Our Reference: SYD13/01382 (A16365739)
DP&E Ref: SSD 6236

**AMENDED EIS FOR ENERGY FROM WASTE FACILITY
HONEYCOMB DRIVE EASTERN CREEK**

Reference is made to DP&E's correspondence dated 12 December 2016 with regard to the abovementioned Development Application, which was referred to Roads and Maritime Services (Roads and Maritime) for comment.

Project	Title
ENERGY FROM WASTE ELECTRICITY GENERATION PLANT, EASTERN CREEK	ESTATE ROAD TYPICAL SECTIONS AND DETAILS

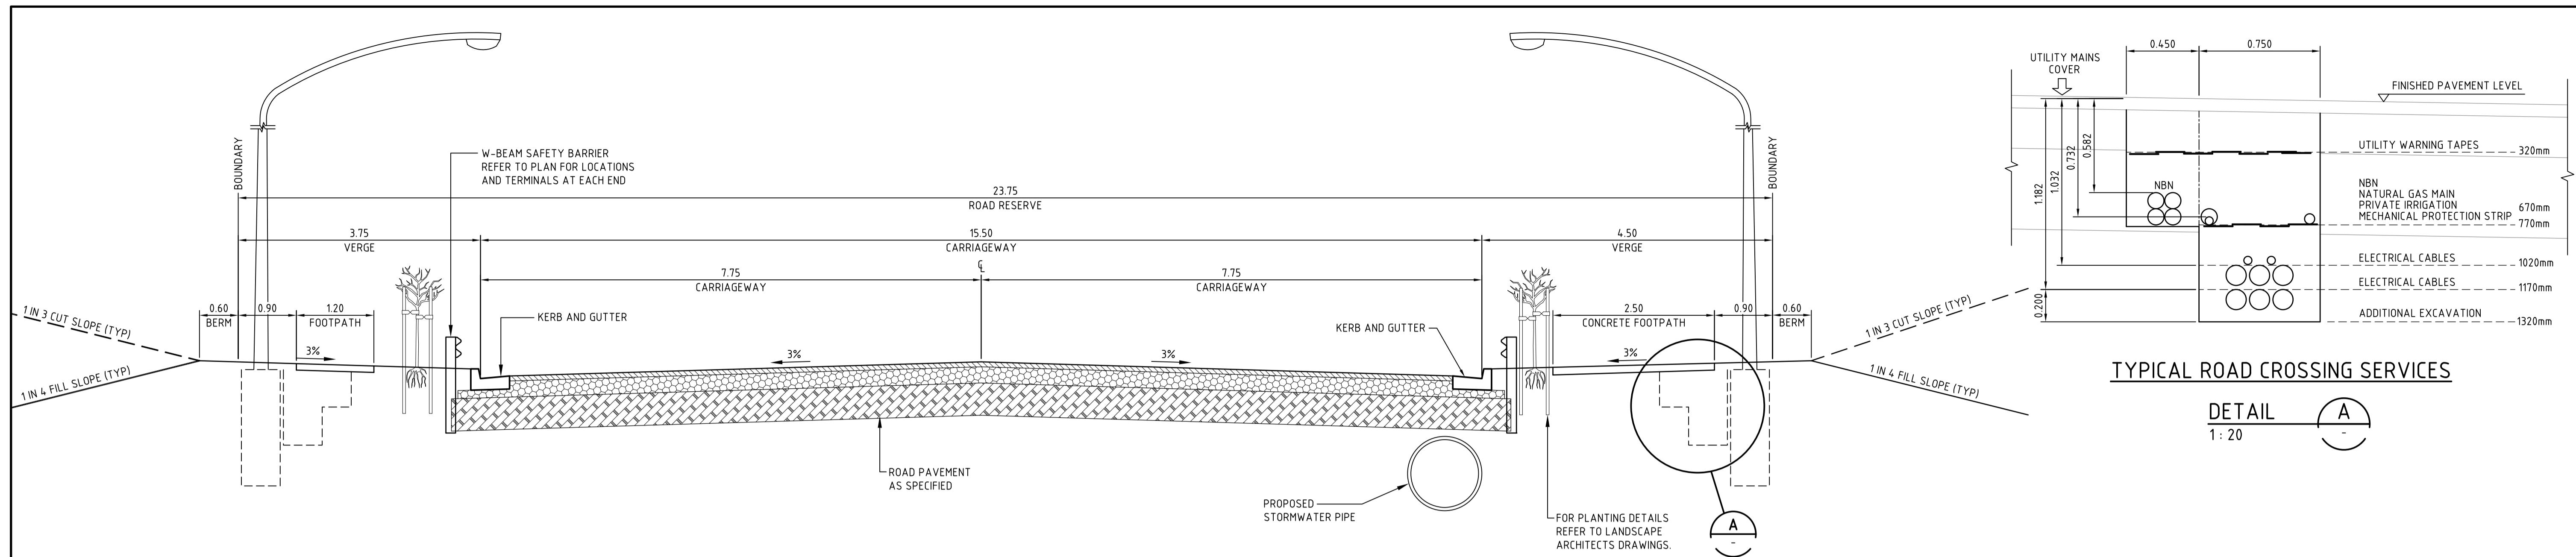
1. The applicant is requested to provide an electronic copy of the SIDRA 6 modelling of the surrounding intersections, in particular the Wallgrove Road and Wonderland Drive intersection, to allow further assessment of the traffic impacts of the proposal.
2. Further clarification is requested from the applicant regarding the proposed future access to Archbold Road. The applicant is requested to align the proposal with the revised RMS intersection location so that the development is consistent with the RMS concept design for Archbold Road (see attached plans for further information).
3. Further clarification is requested from the applicant regarding the proposed access road from Honeycomb Drive. Road design details should be provided for assessments.
